09/04/2021

**St Marys Resource Recovery Facility (Borg) (SSD-10474)
Response to submissions**

Attachment 1

SWEPT PATH ANALYSIS - SUBJECT SITE - VEHICLE ACCESSING SILO
AS2890.2 12.5m HEAVY RIGID VEHICLE

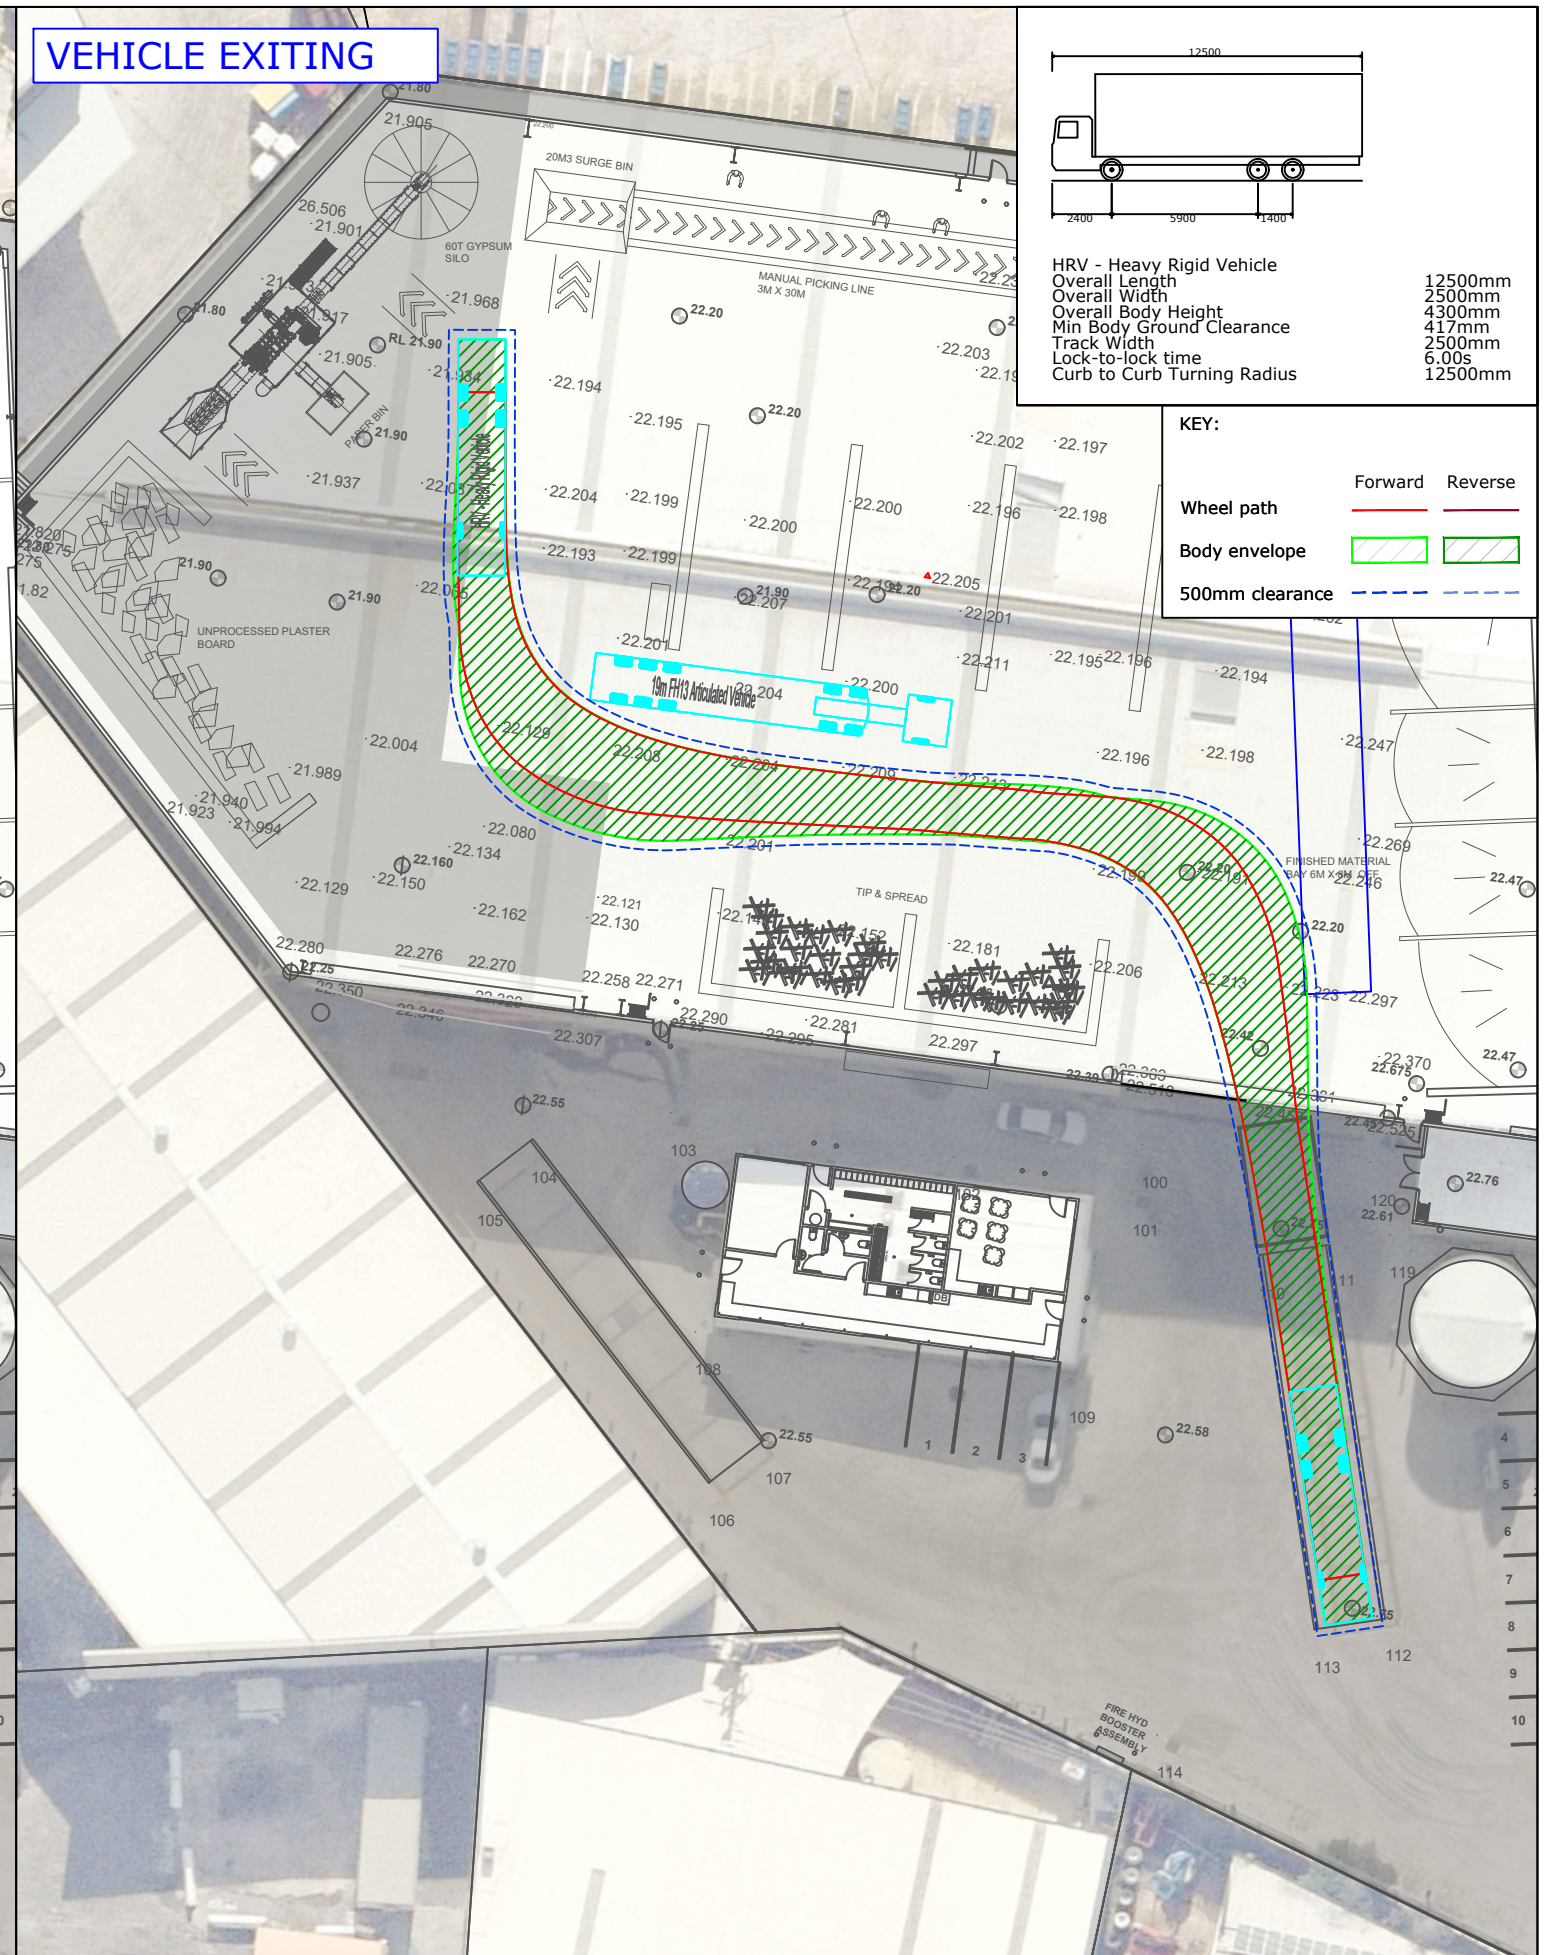
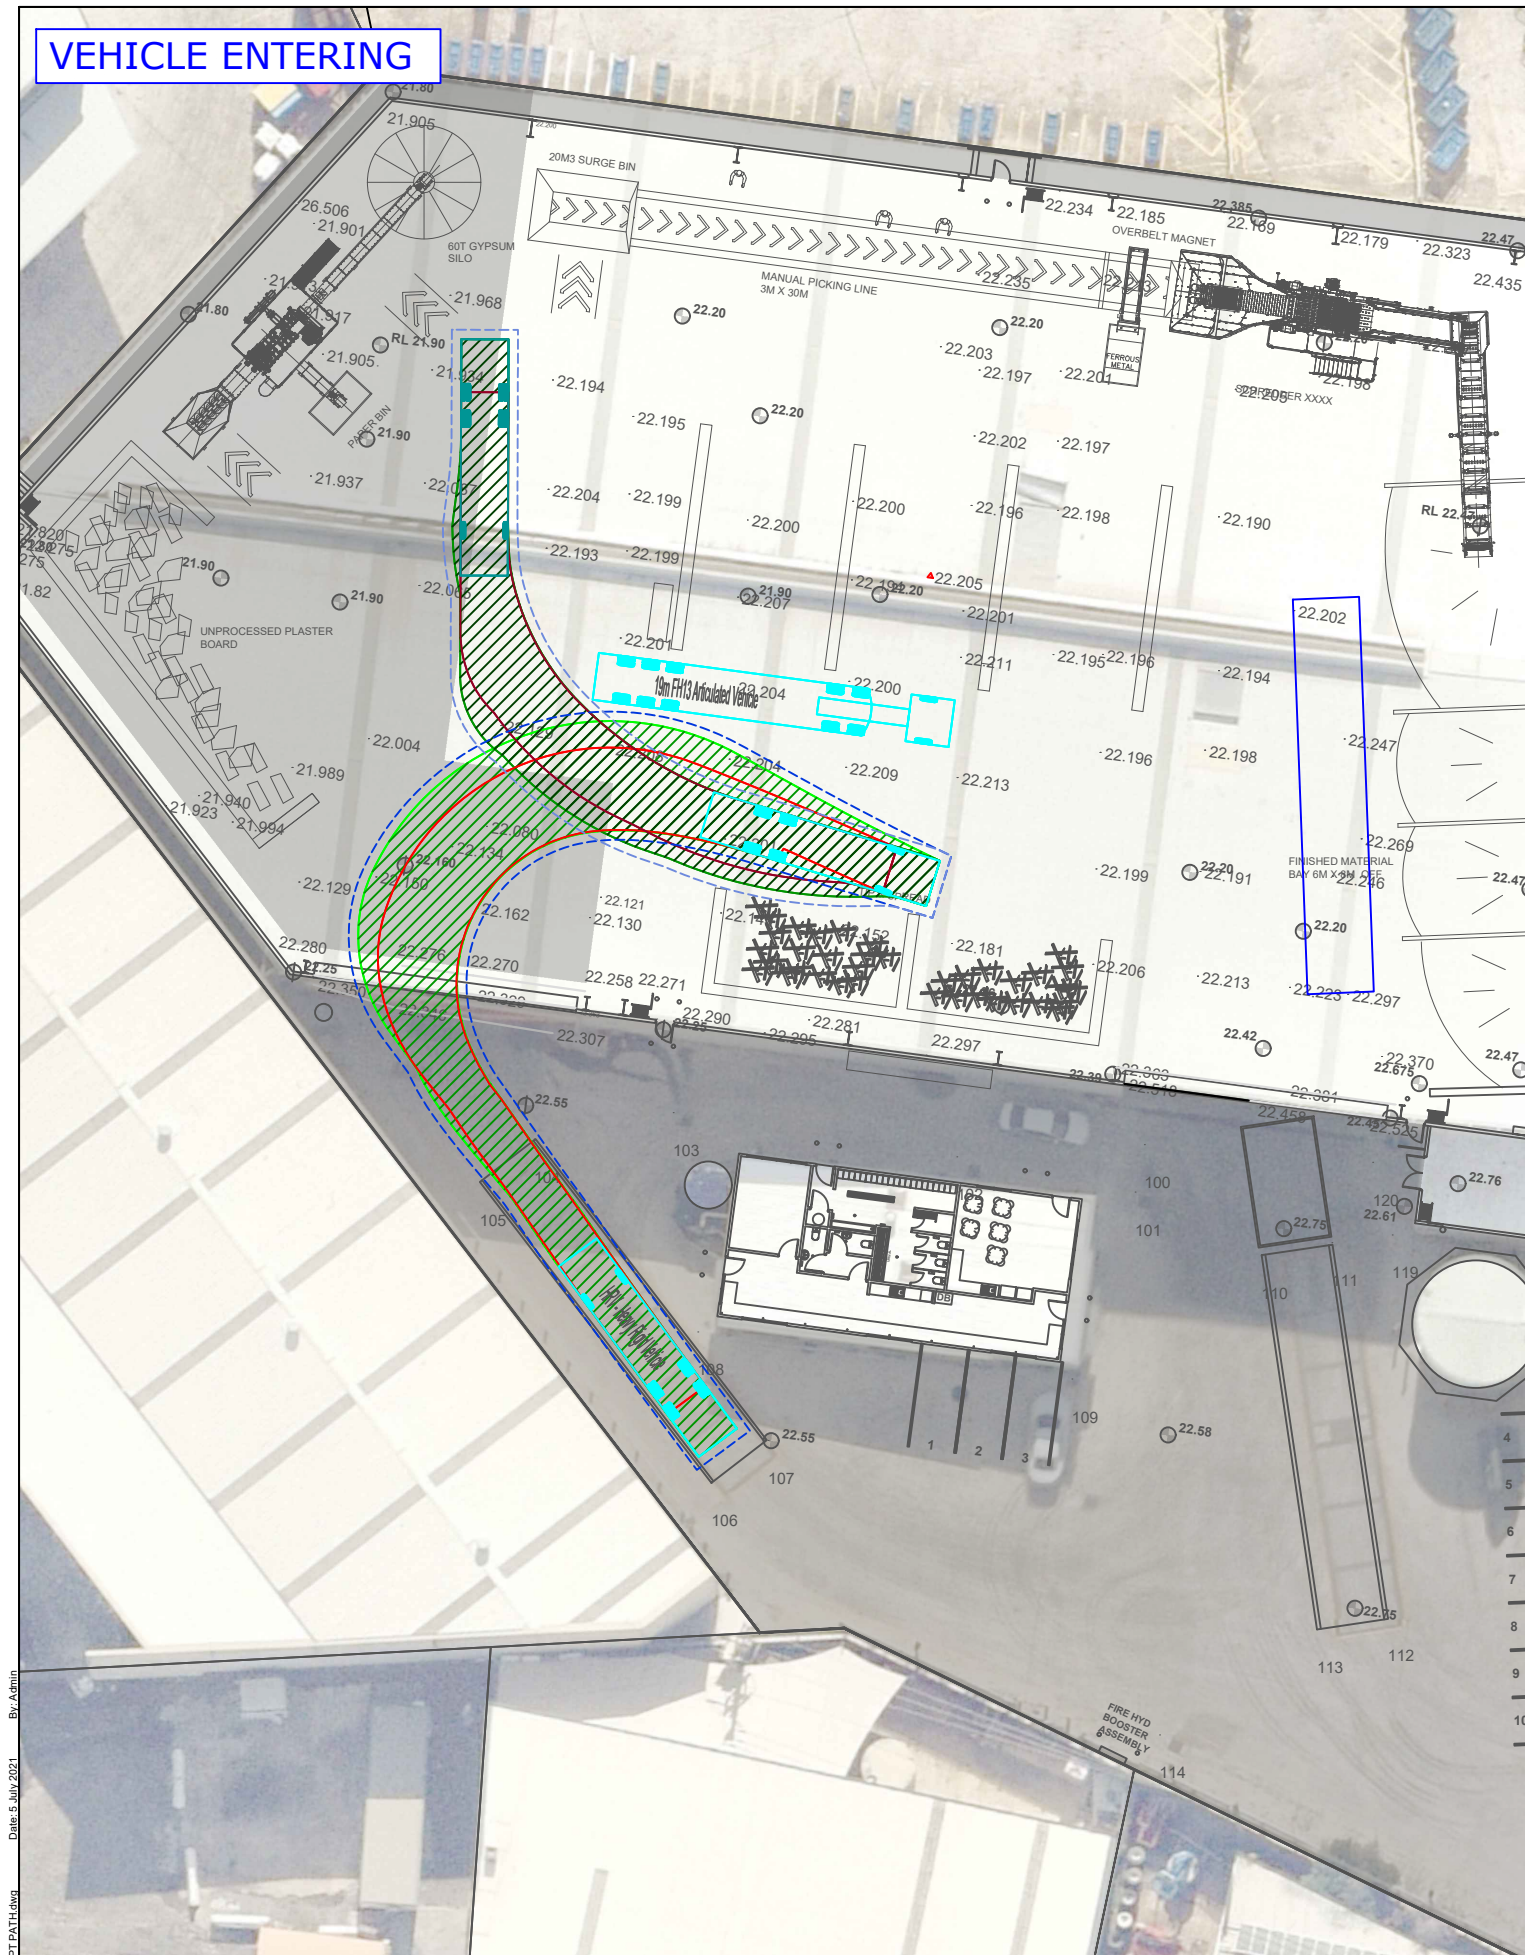
- Please clarify whether there is sufficient room in the warehouse building for heavy vehicles to manoeuvre, particularly when collecting processed material including from the gypsum silo and while front-end loaders or other machinery is in operation.
